DECISION NOTICE

Application Ref: WA/98/21/PL

Removal of outdoor storage, including caravan and polytunnels and the erection of 7 No. units comprising of 12 offices and 3 workshops, associated parking, drainage and turning spaces (resubmission following WA/58/21/PL). This site is in CIL Zone 3 (Zero Rated) as other development.

Existing Block Plan
Scale 1:500

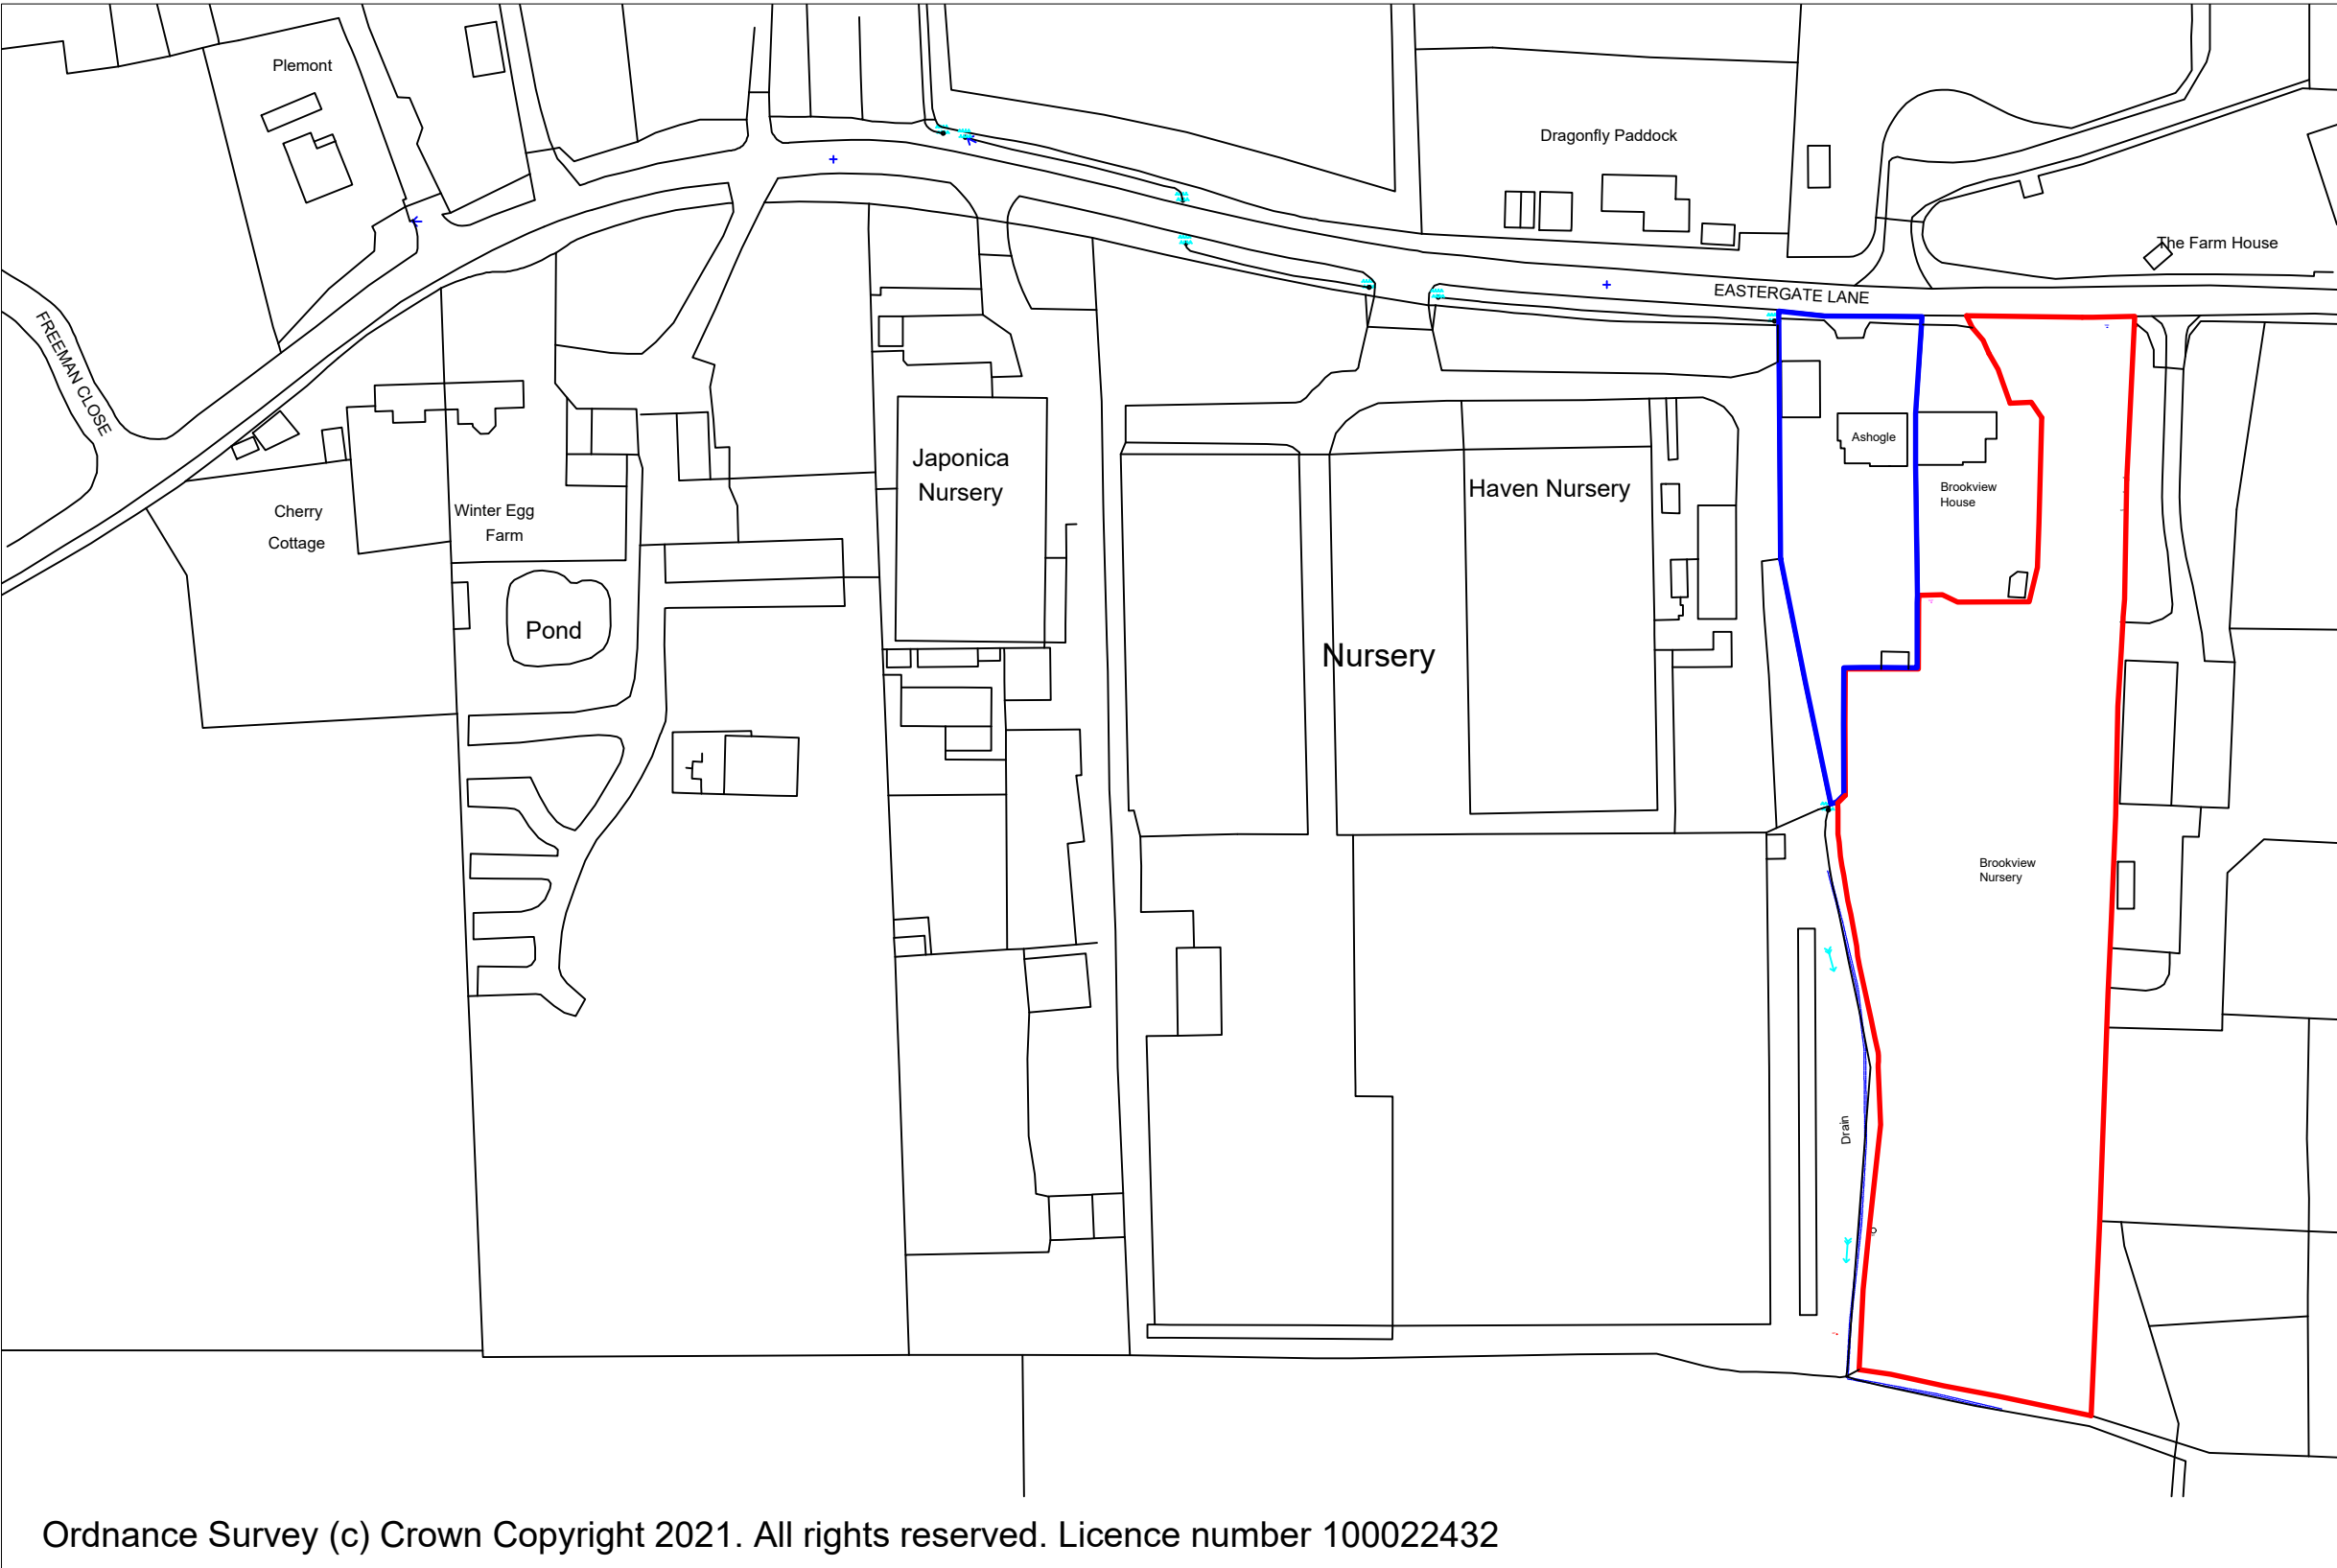
- 1 The supporting documents are collectively unclear as to which of the important trees on the site are to be removed but it is clear the layout will result in substantial and potentially damaging activity in the Root Protection Areas of the vast majority of retained trees. This combined with potential damage during construction, ground compaction and future pressure to prune or fell will result in clear harm to such trees and the contribution they make to the character of the area, the local landscape and to on-site ecology in conflict with Arun Local Plan policies ENV DM4, ENV DM5, D DM1 & LAN DM1, Walberton Neighbourhood Development Plan policies VE3 & VE10 2020 and the NPPF.

- 2 Given the discrepancies in the application regarding the impact on trees, it is not possible to determine whether the proposed development will result in any significant adverse effects upon the Singleton and Cocking Tunnels Special Area of Conservation, the bat species associated with that site or its functionally linked habitats (in respect of loss of foraging habitat and/or severance of commuting flight-lines). The proposal is therefore in conflict with Arun Local Plan policy ENV DM1 and Walberton Neighbourhood Development Plan policy VE10 2020.
